GRADING AND EROSION CONTROL PLAN CHECKLIST

See my comments on the Site Development Plan

DESIGN	DRAWN	CHKD
SWK	SWK	TOP
SCALE	H: 1" = 20' V: 1" = XXX'	
JOB No.	020441-01-001	
DATE :	02/09/2021	
SHEET	C2.0

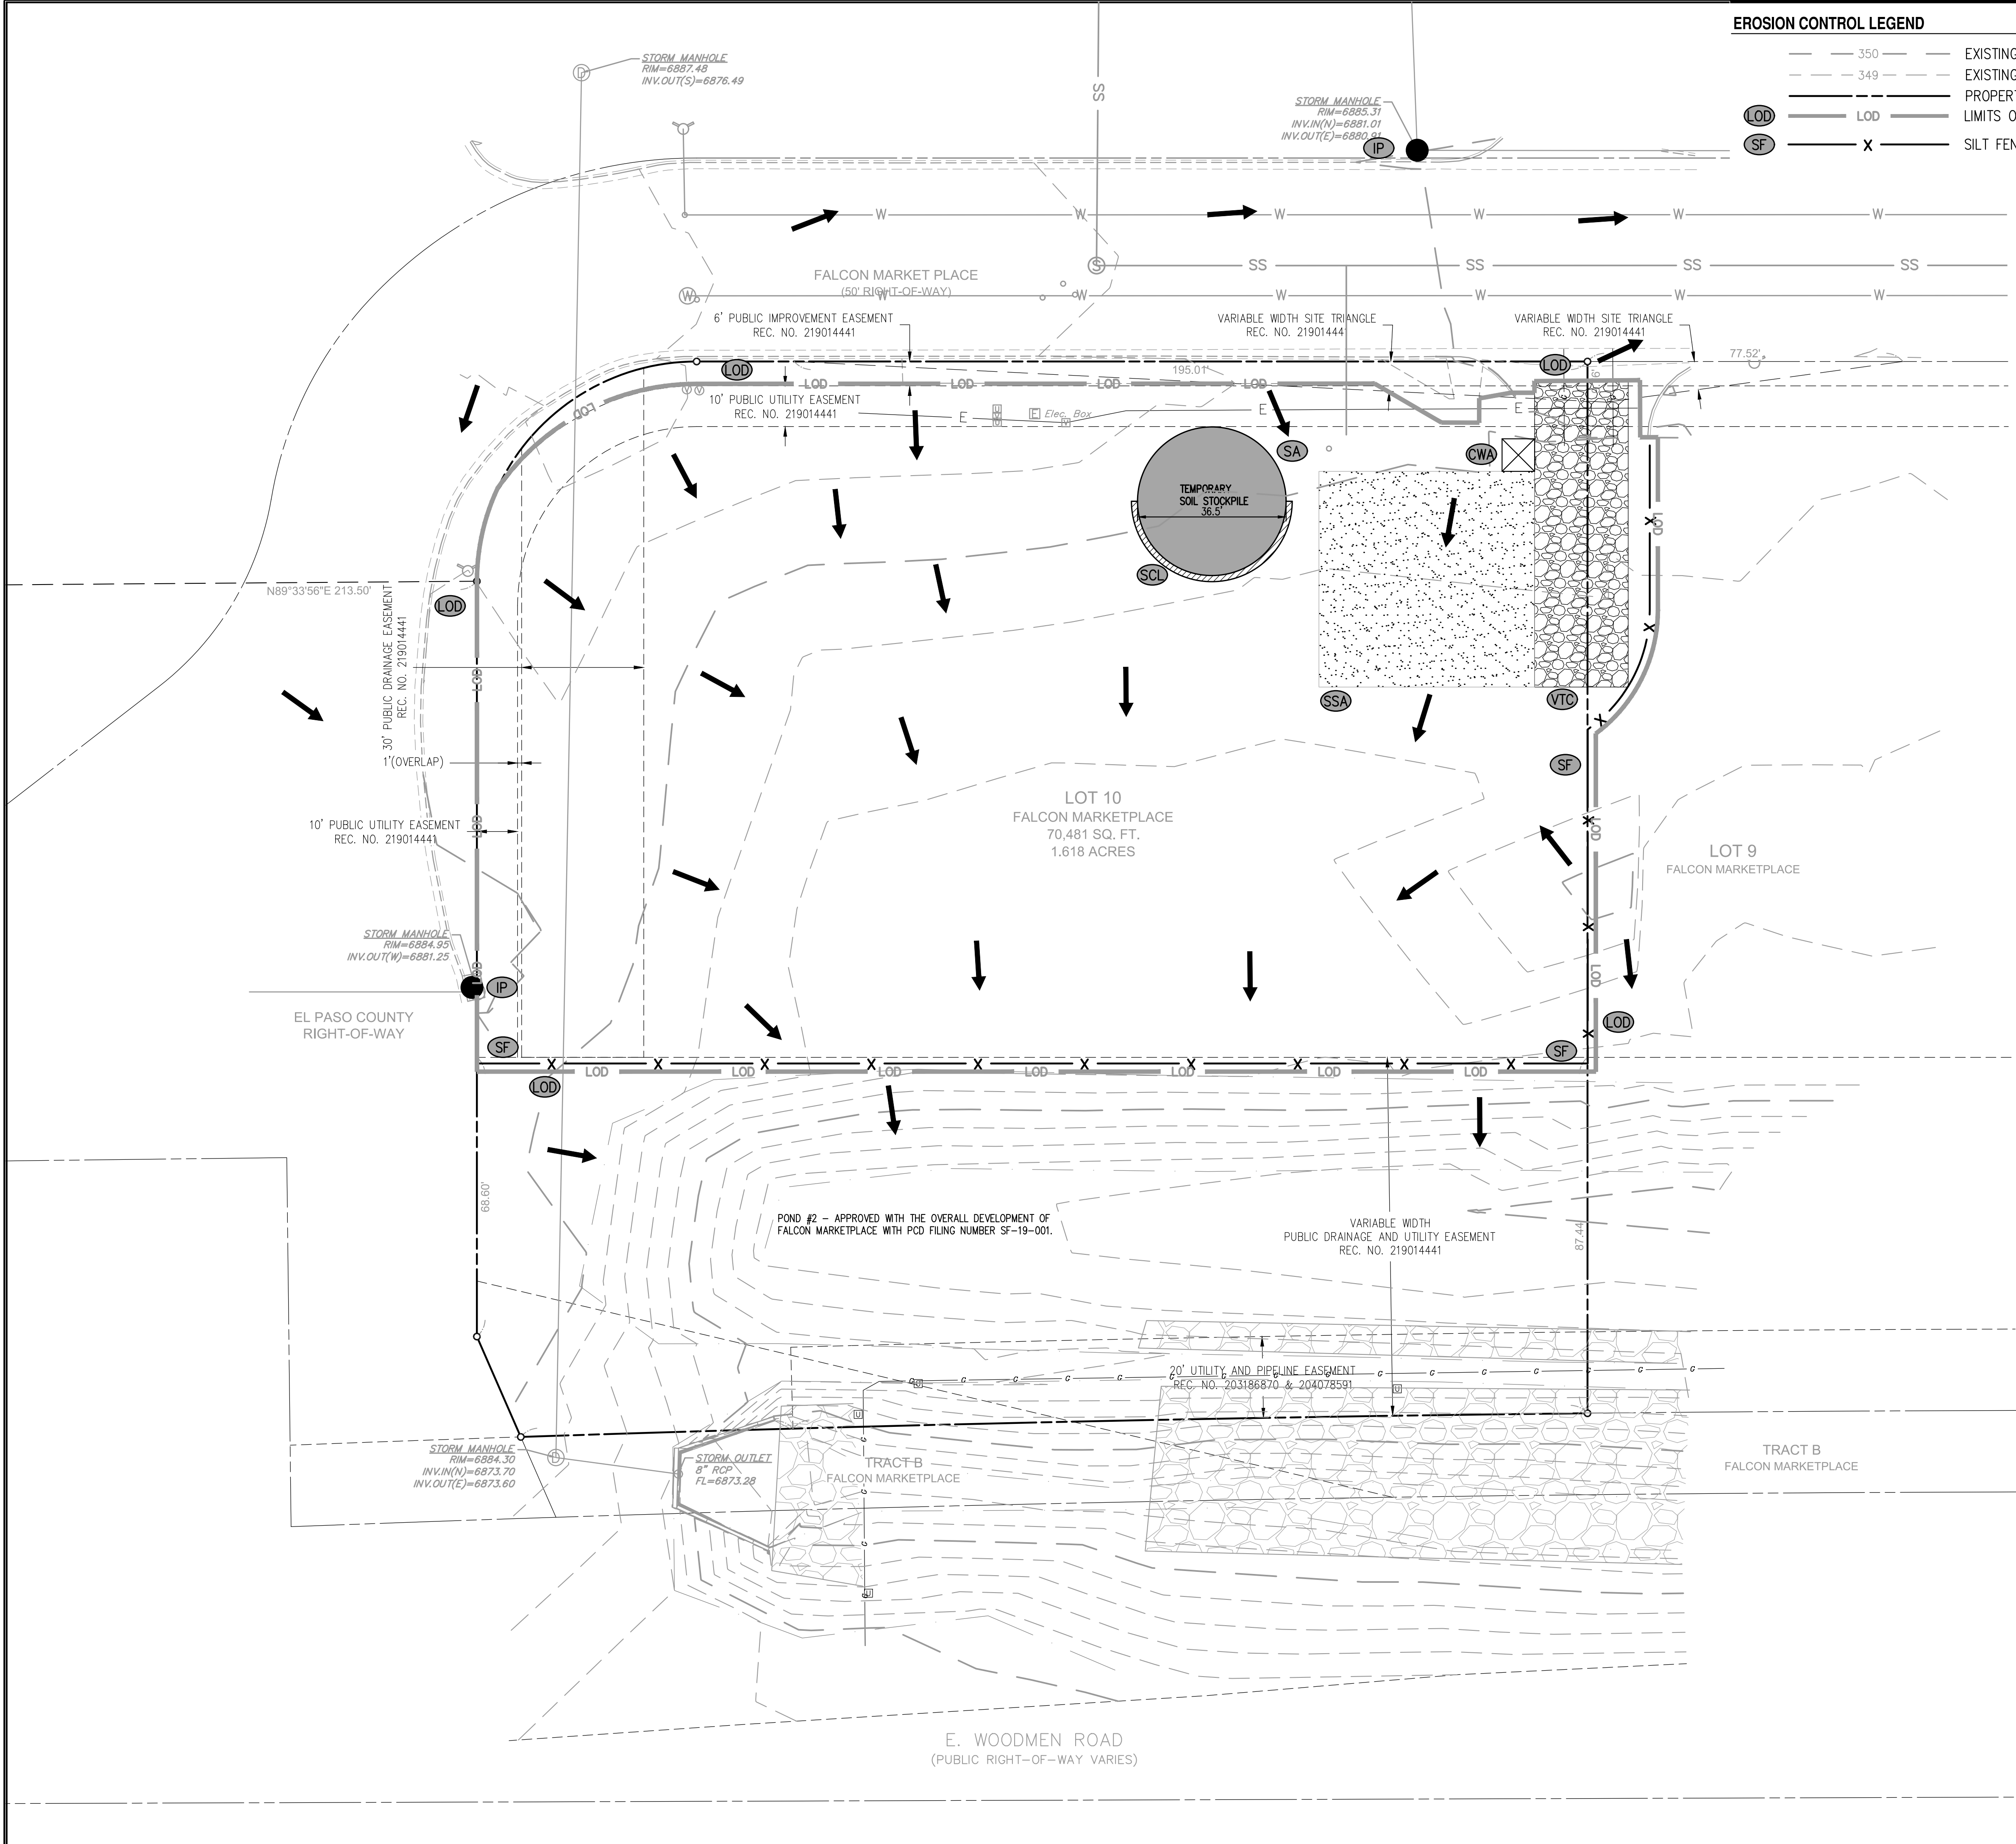
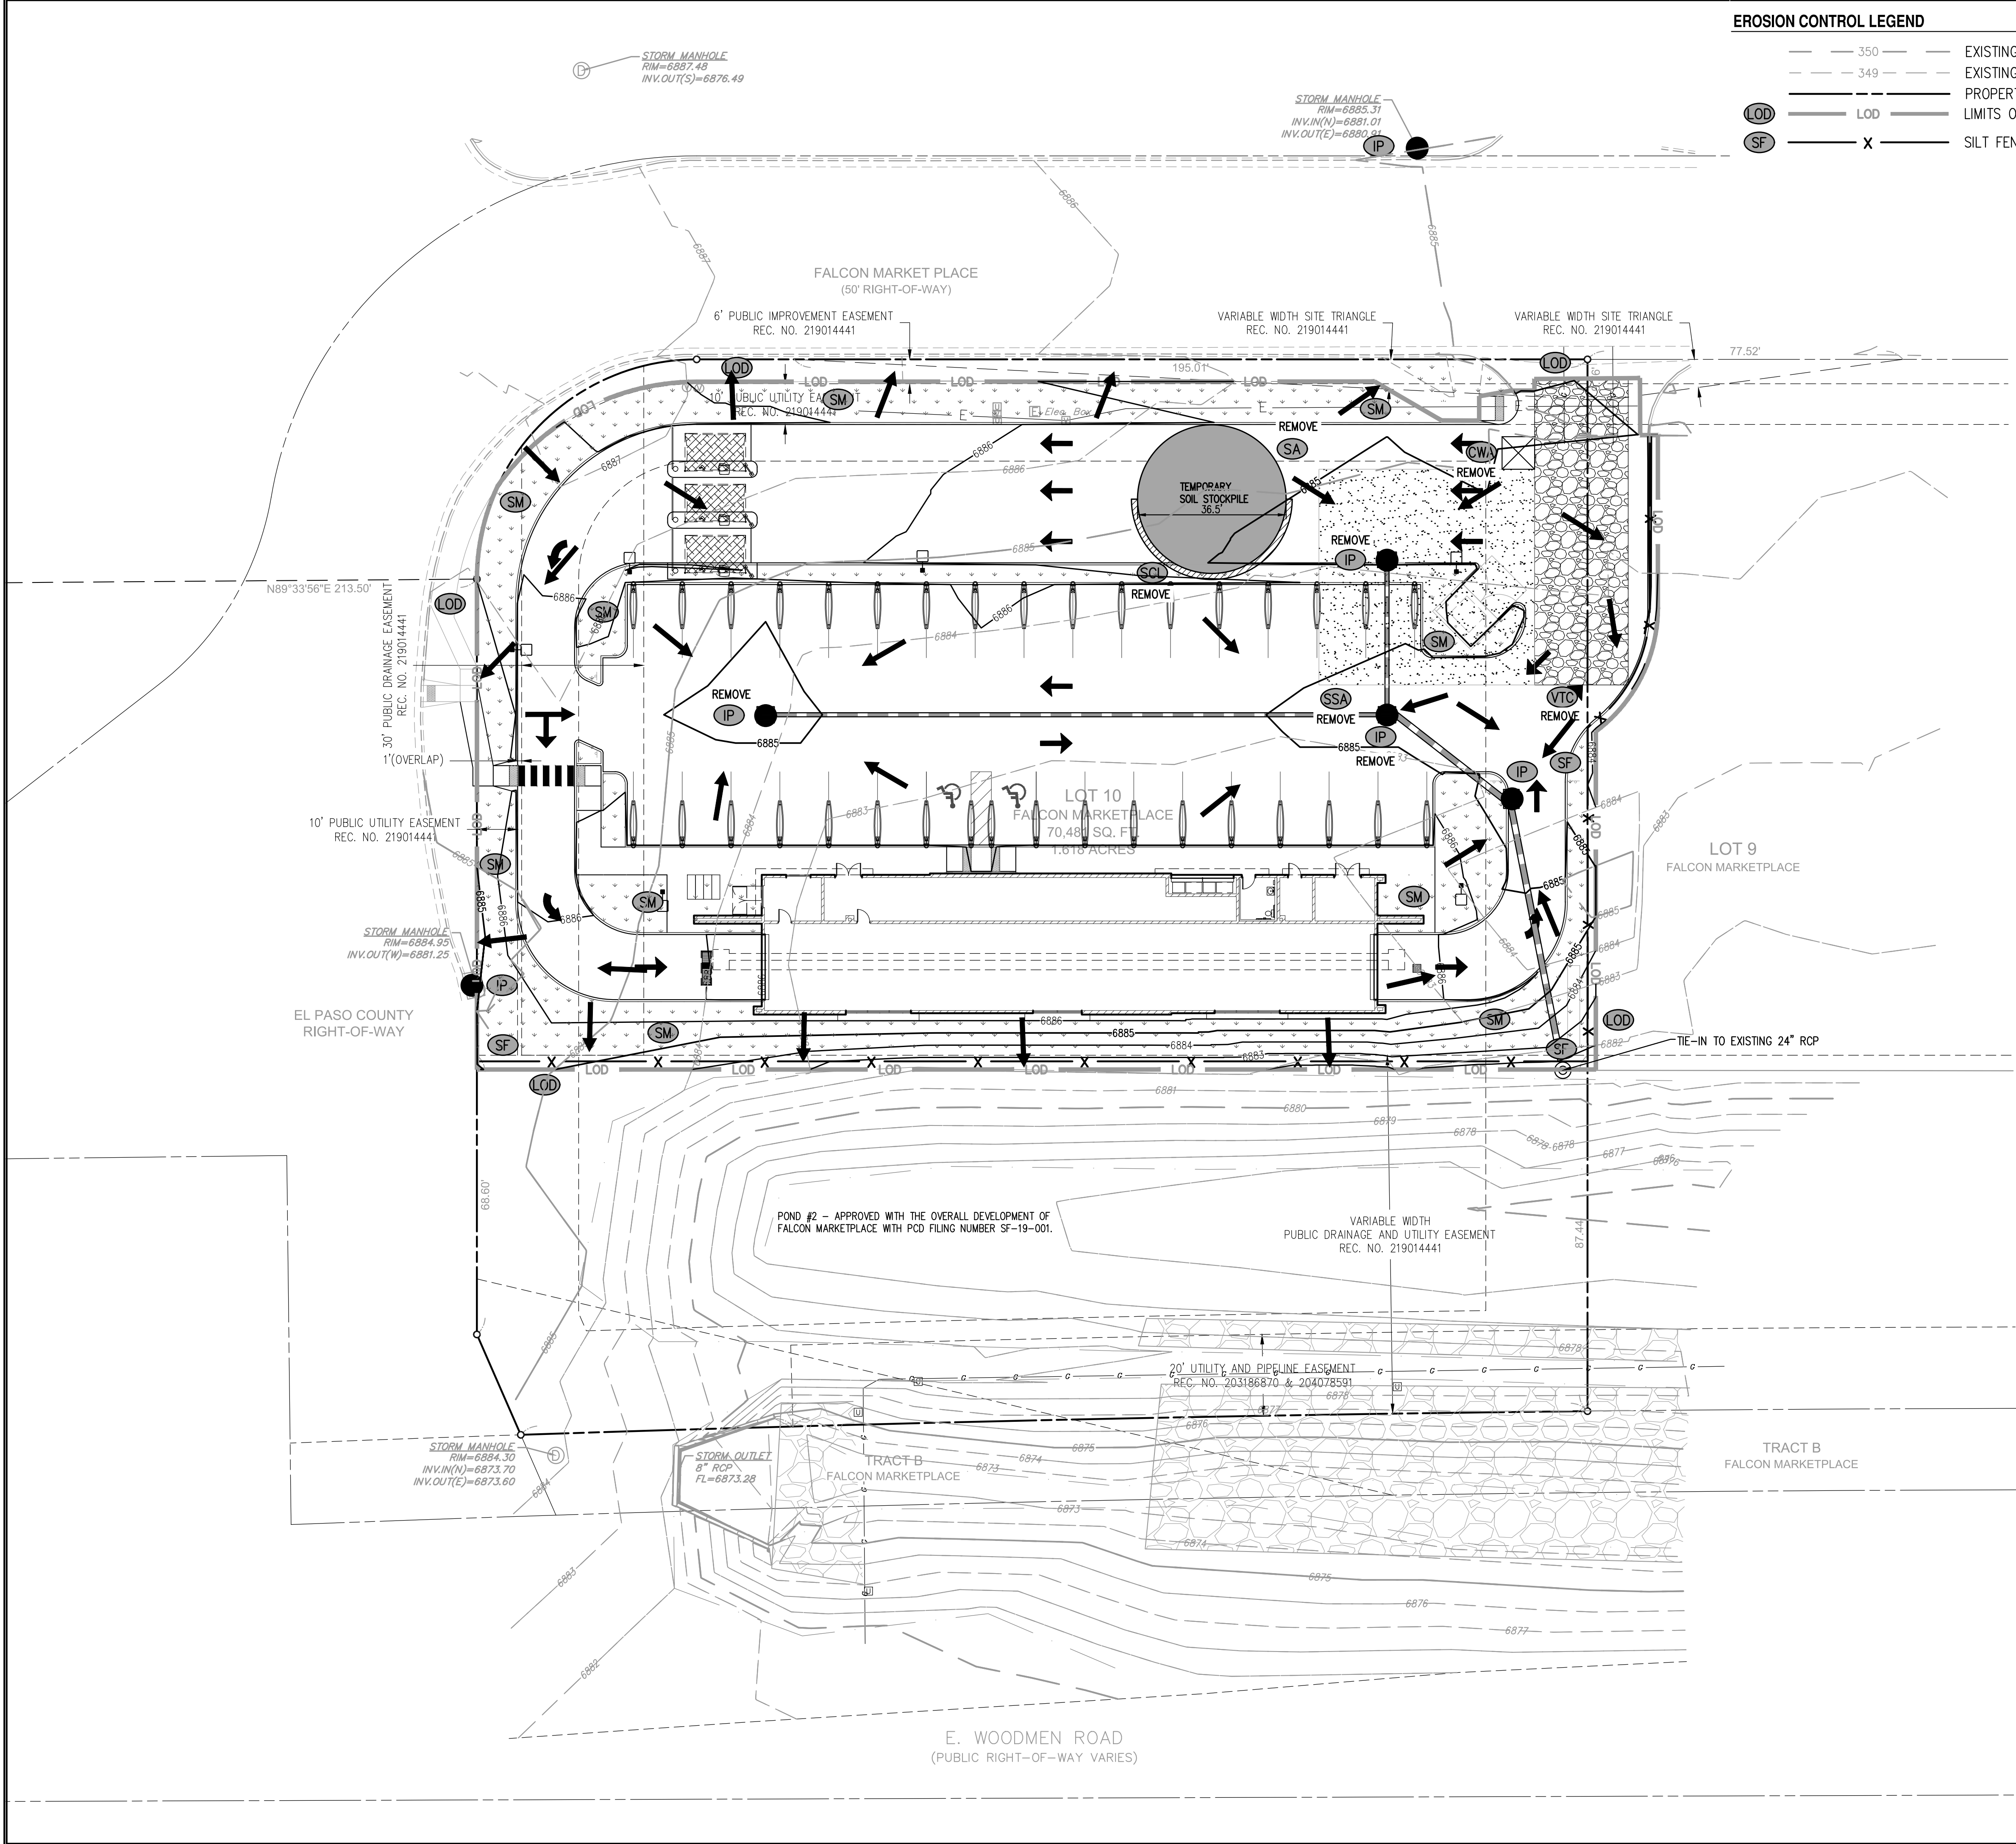
Applicant	PCD
1. GRADING AND EROSION CONTROL PLAN			
a	Vicinity map.		Y
b	Adjacent city/town/jurisdictional boundaries, subdivision names, and property parcel numbers labeled.		N
c	North arrow and acceptable scale (1"=20' to 1"=100').		Y
d	Legend for all symbols used in the plan.		Y
e	Existing and proposed property lines. Proposed subdivision boundary for subdivision projects.		Y
f	All existing structures.		Y
g	All existing utilities.		Y
h	Construction site boundaries.		N
i	Existing vegetation (notes are acceptable in cases where there is no notable vegetation, only grasses/weeds, or site has already been stripped).		N
j	FEMA 100-yr floodplain.	See comments	N/A
k	Existing and proposed water courses including springs, streams, wetlands, detention ponds, stormwater quality structures, roadside ditches, irrigation ditches and other water surfaces. Show maintenance of pre-existing vegetation within 50 feet of a receiving water.		Y

l	Existing and proposed contours 2 feet or less (except for hillside).		Y
m	Limits of disturbance delineating all anticipated areas of soil disturbance.		N
n	Identify and protect areas outside of the construction site boundary with existing fencing, construction fencing or other methods as appropriate.	none	N/A
o	Offsite grading clearly shown and called out.	No offsite grading	N/A
p	Areas of cut and fill identified.		N
q	Conclusions from soils/geotechnical report and geologic hazards report incorporated in grading design (slopes, embankments, materials, mitigation, etc.)		Y
r	Proposed slopes steeper than 3:1 with top and toe of slope delineated. Erosion control blanketing or other protective covering required.		N/A
s	Stormwater flow direction arrows.		Y
t	Location of any dedicated asphalt / concrete batch plants.		N/A
u	Areas used for staging, storage of building materials, soils (stockpiles) or wastes. The use of construction office trailers requires PCD permitting.		Y
